From: [REDACTED]
Sent: 01 January 2023 17:51
To: Planning
Subject: Re: Planning application 3/2022/1129 FAO David Kilmartin

Address of Development: Bridge Hey Wood Caravan Park Dunkirk Farm Read BB12 7RR

"Retrospective change of use with minor engineering works and associated landscaping works for the reuse of the former railway embankment and track bed to form an informal recreational amenity area in association with the adjacent holiday park"

Bridge Heywood Woodland Walk Map

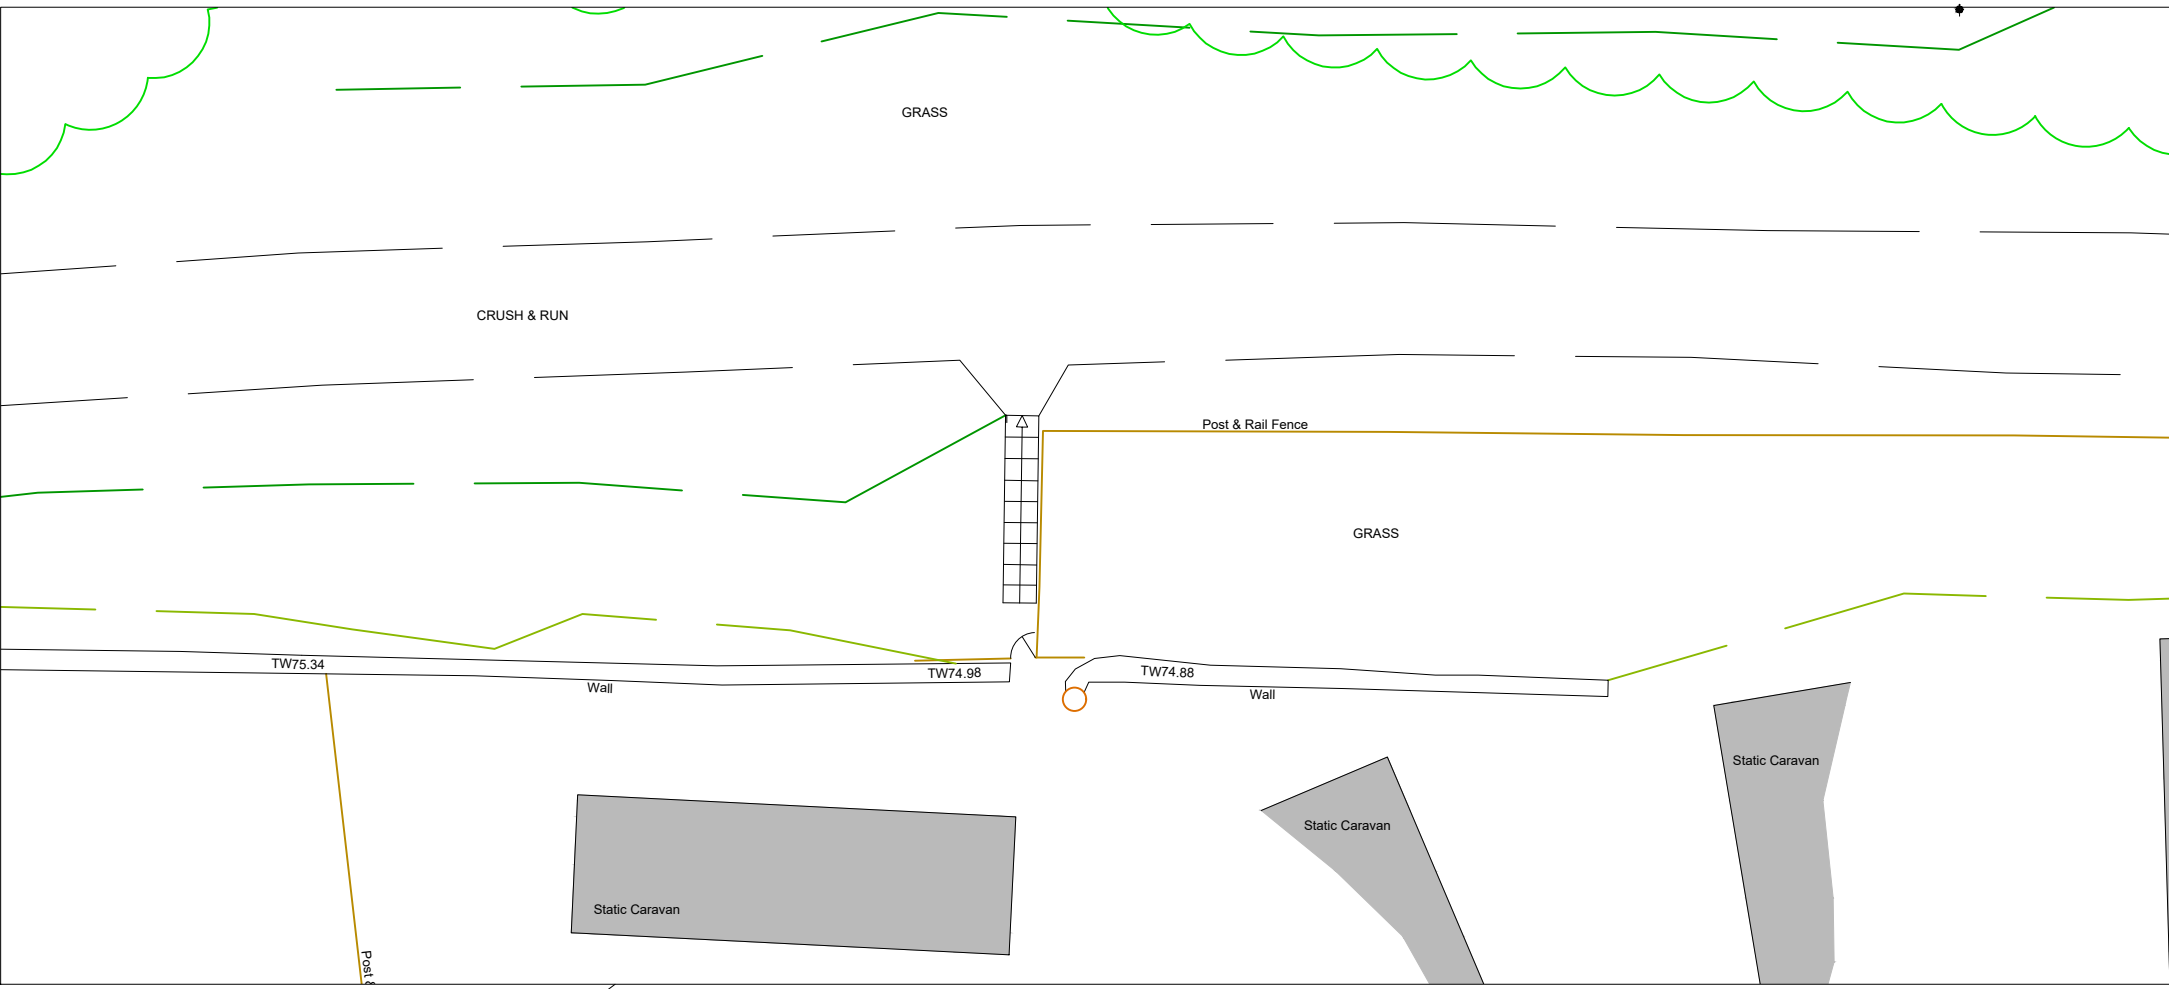
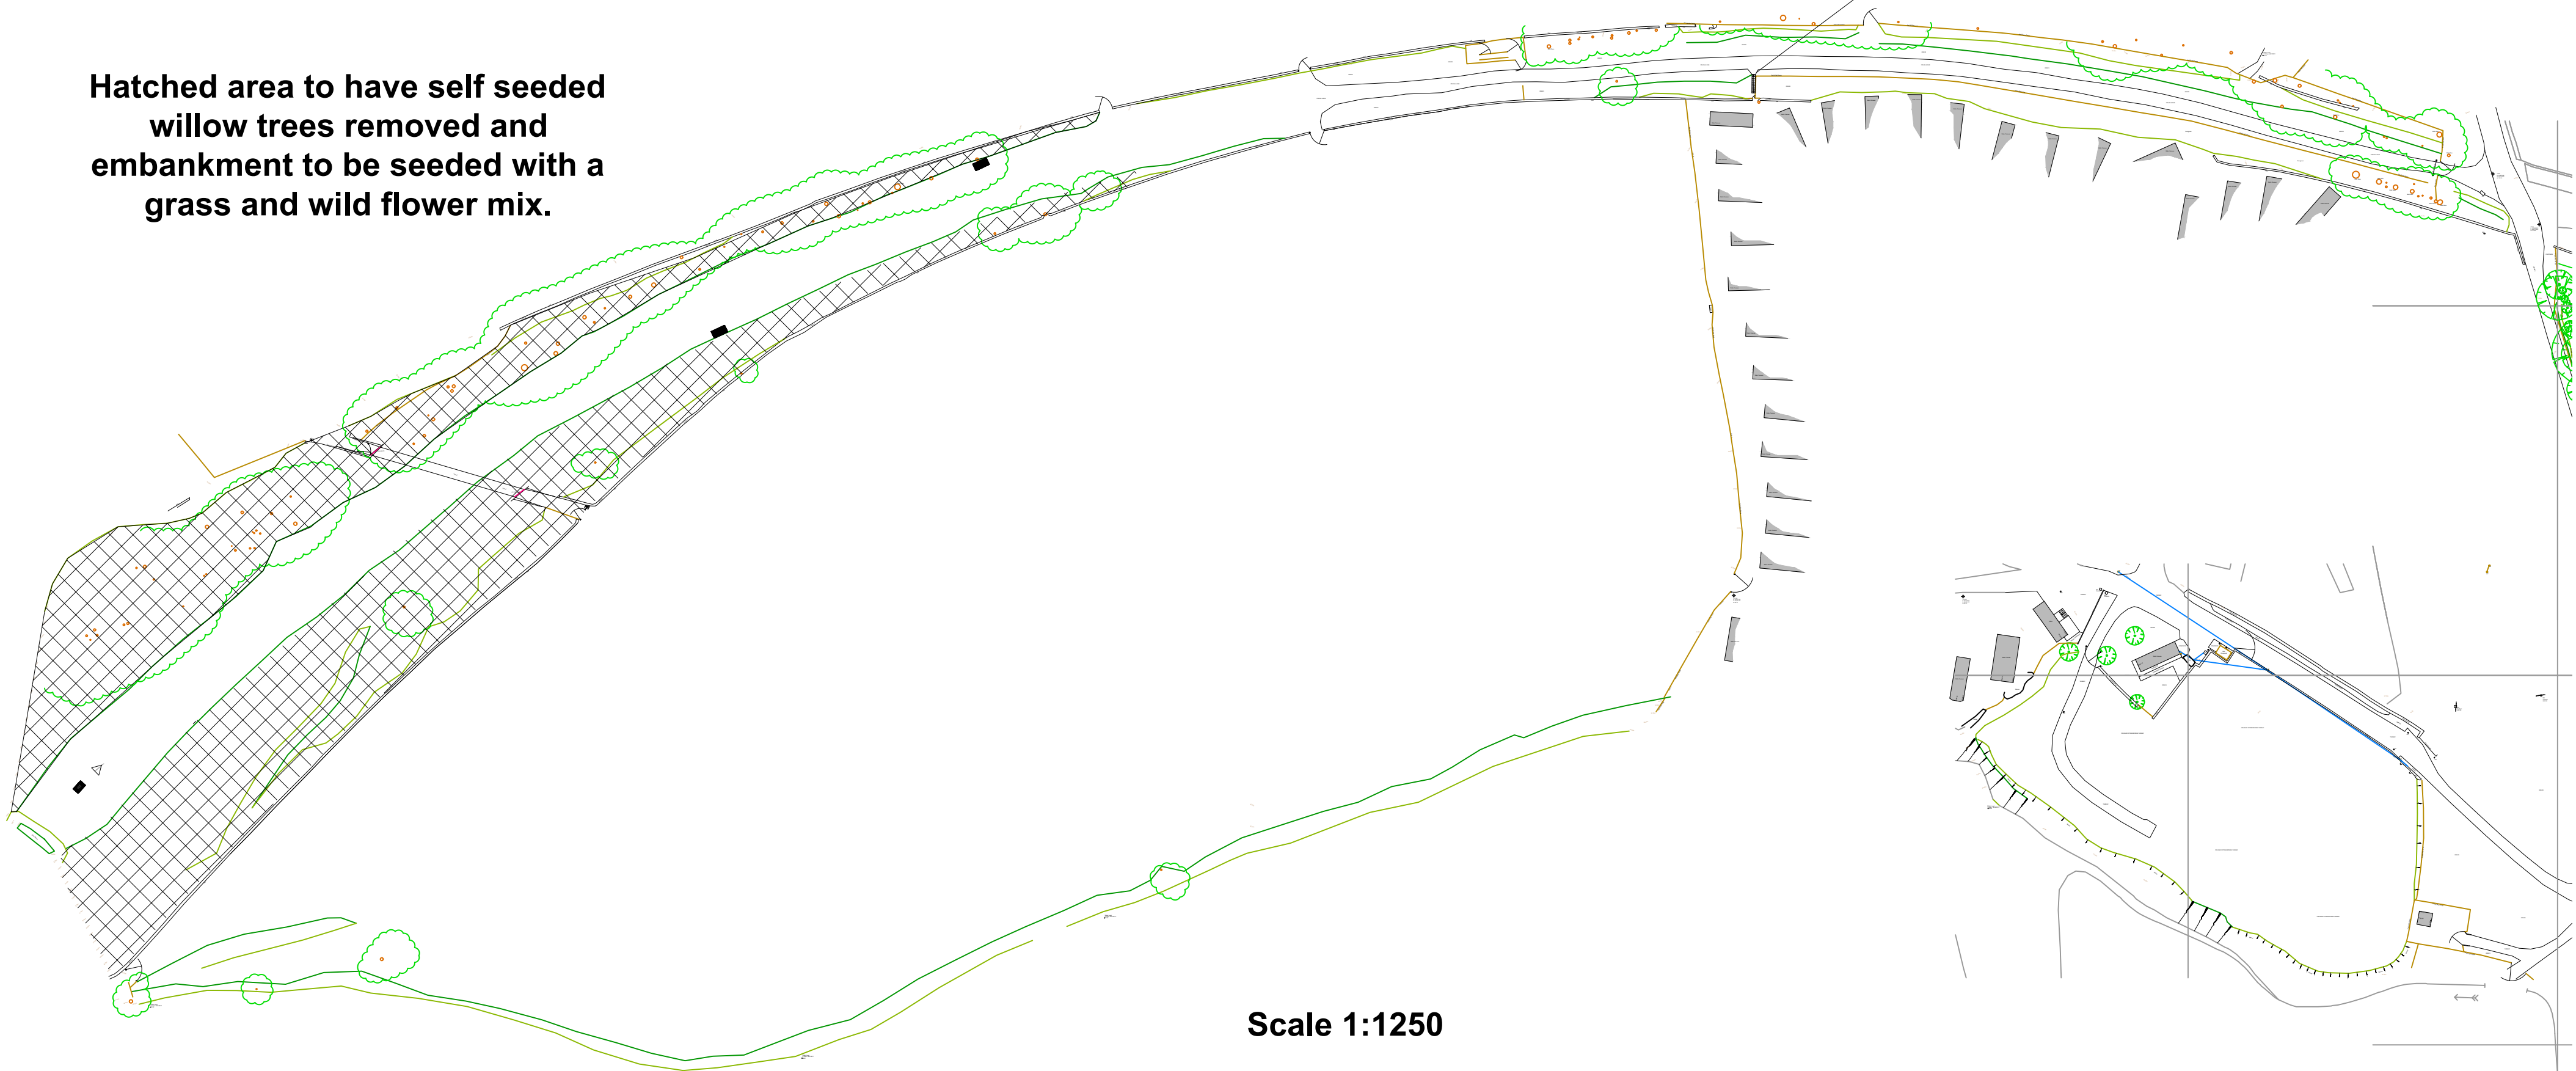
The applicant has indicated NO to both of these. This is not correct. At the start of the works in this area the embankment was covered with reasonably mature trees 70+ years of age, with some older trees on the sides of the embankment. These covered a full range of species including Oak, Willow, Hawthorn, Hazel, etc. as per the southern side of the viaduct. See the attached tree removal document.

3. In the covering letter the included map shows the footpath for the caravan residents going under the viaduct. The applicant does not own this section of land, this is owned by [REDACTED] On the deed there permitted access for the residents of the caravan park hence should not be included within the designated walks.

4. In the covering letter the included map shows the viaduct as 'No access over the viaduct' this is incorrect as the viaduct is fully accessible from the southern end and access for the residents of the caravan park is only prevented by the applicant.
